Please add e-mail and plans to application

Further to our telephone conversation today, thank you for taking the time to explain everything to me. I address below all the points in your consultation email.

Section (1:50)

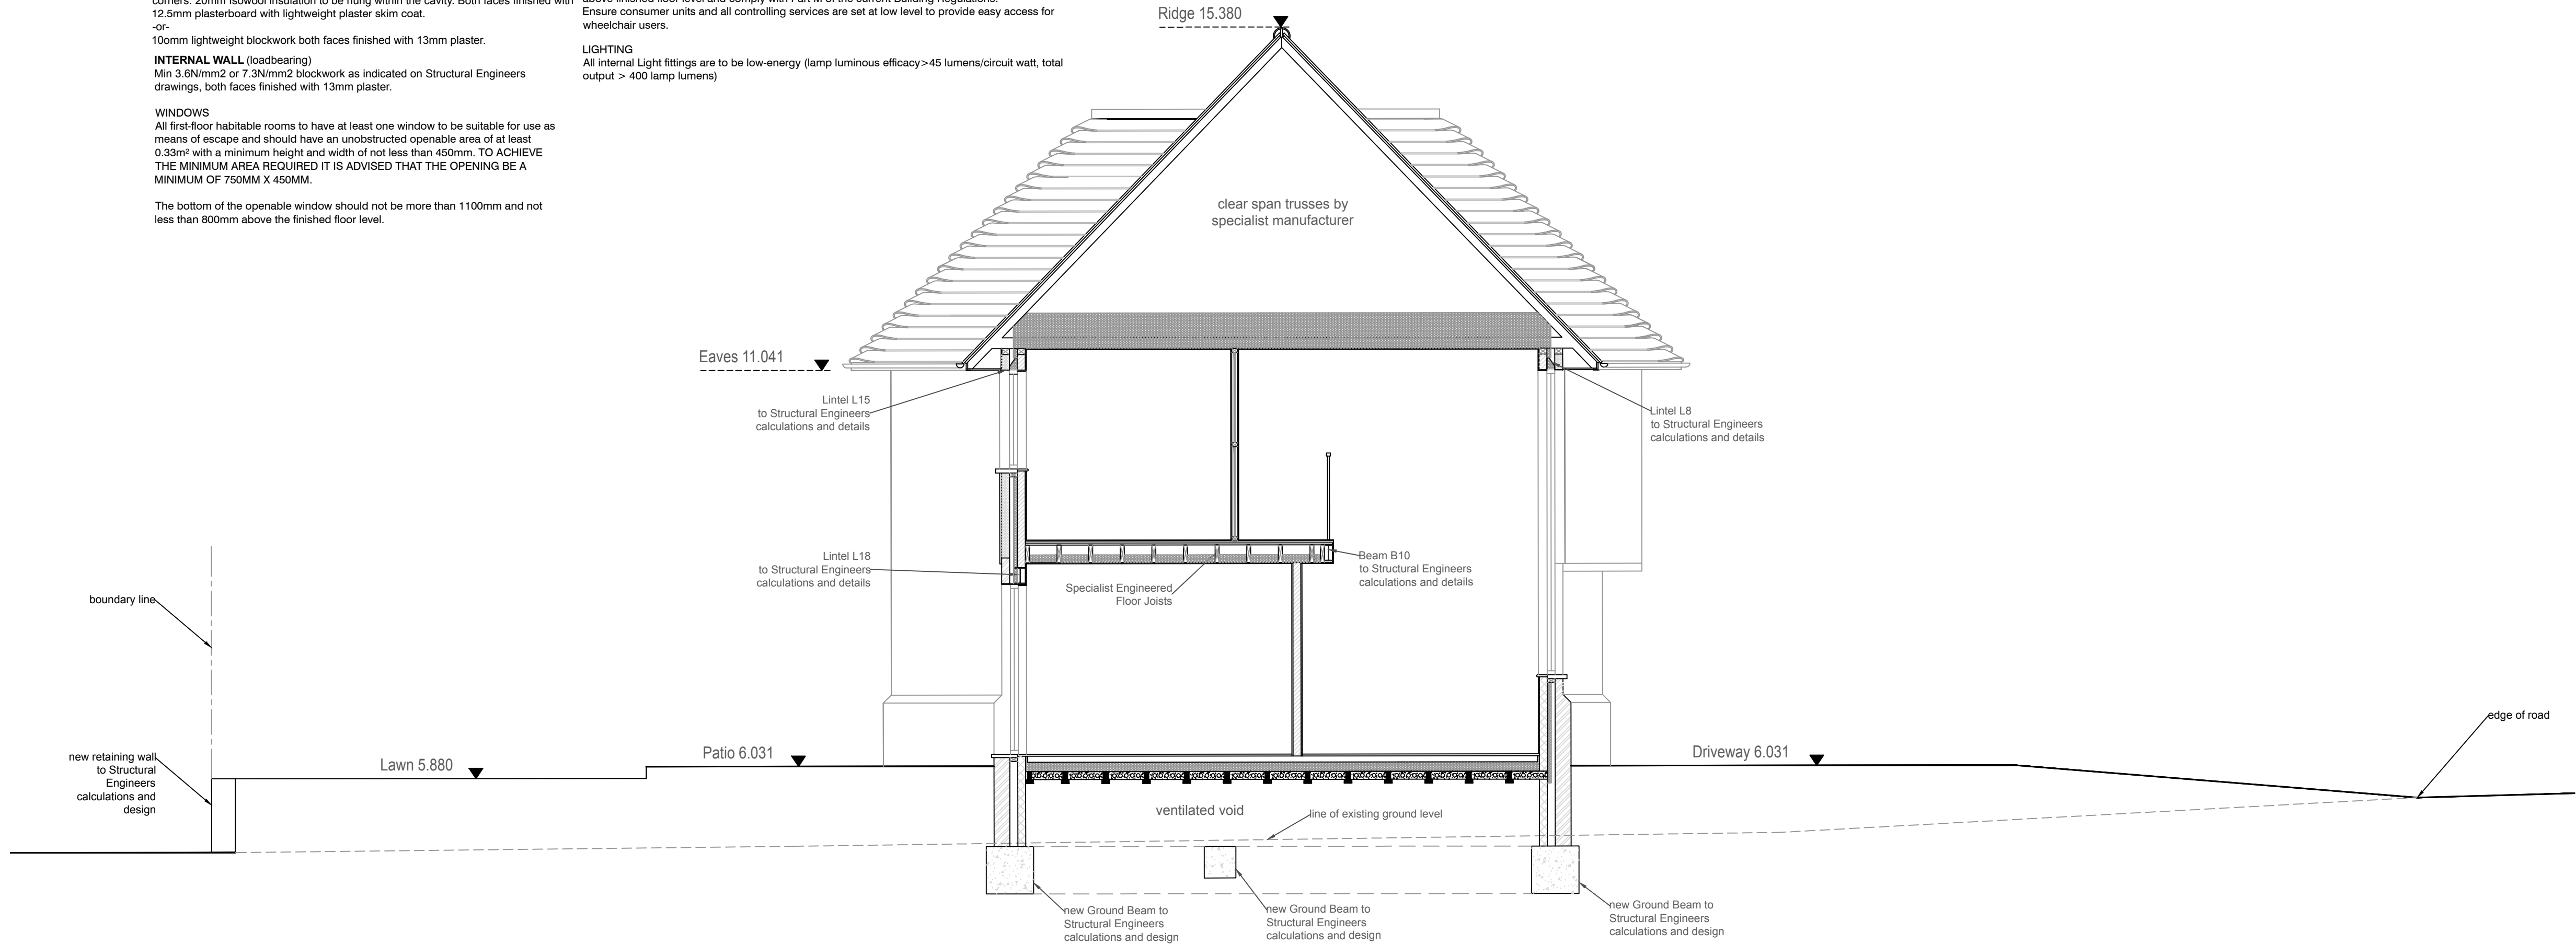
Point 5 – We will be making up the level of the whole site not just the area shown in the drainage plan. I have attached a topographical plan showing the levels of our neighbours and a section of our Building Regulation plans showing the finished levels of the new house. The finished levels on the whole site will ensure that no surface water will be diverted to neighbouring properties. There is no history of a surface water flow path on the surface of the land. Any historical standing water near the site was a dew pond which has since been removed by Ham Manor Golf Club and replaced by an extremely long meandering French Drain, that travels across the 18th and 10th fairways. Any underground flow path will neither be interrupted by us filling the site or our piled foundations.

Date: Dec 19 MASS RETAINING WALL

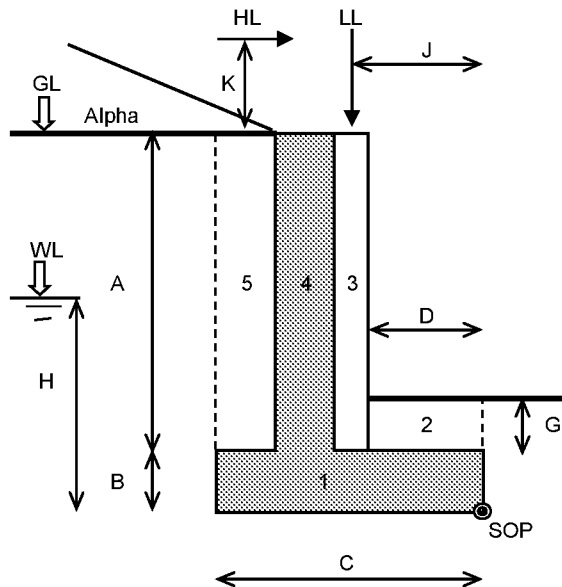
Point 4d – I have attached the structural engineers section and calculations of the retaining wall. It has been designed to allow for any hydrostatic pressure which will allow any surface water to infiltrate through the ground below. If you wish us to add weep holes we can.

Typical Silt Trap Inspection Chamber Detail
(for use in areas not subject to vehicle loading)

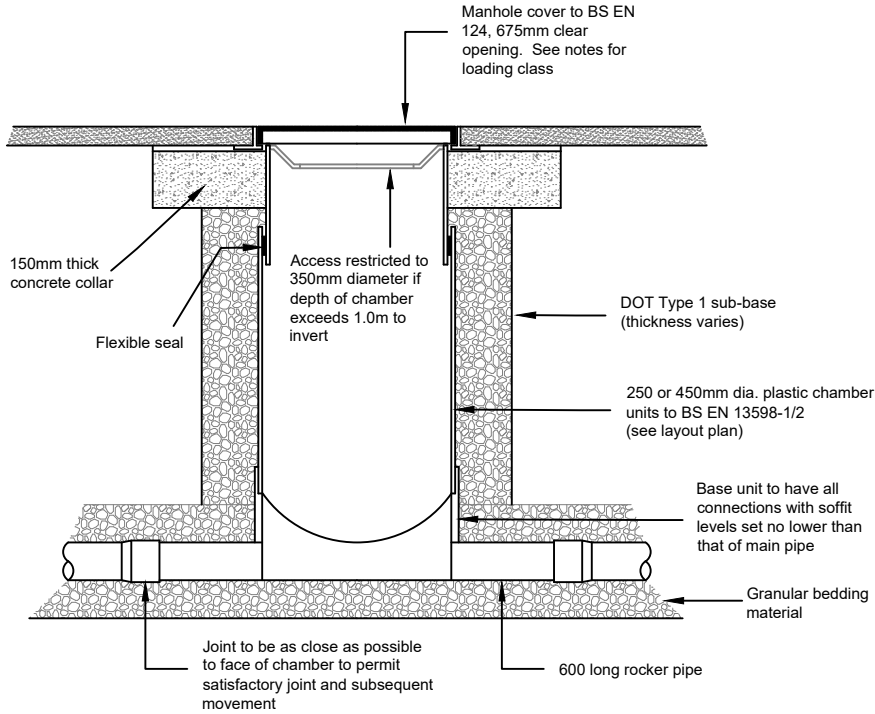
Point 1 & 2 our drainage engineer has addressed. We will install the silt traps you have requested.
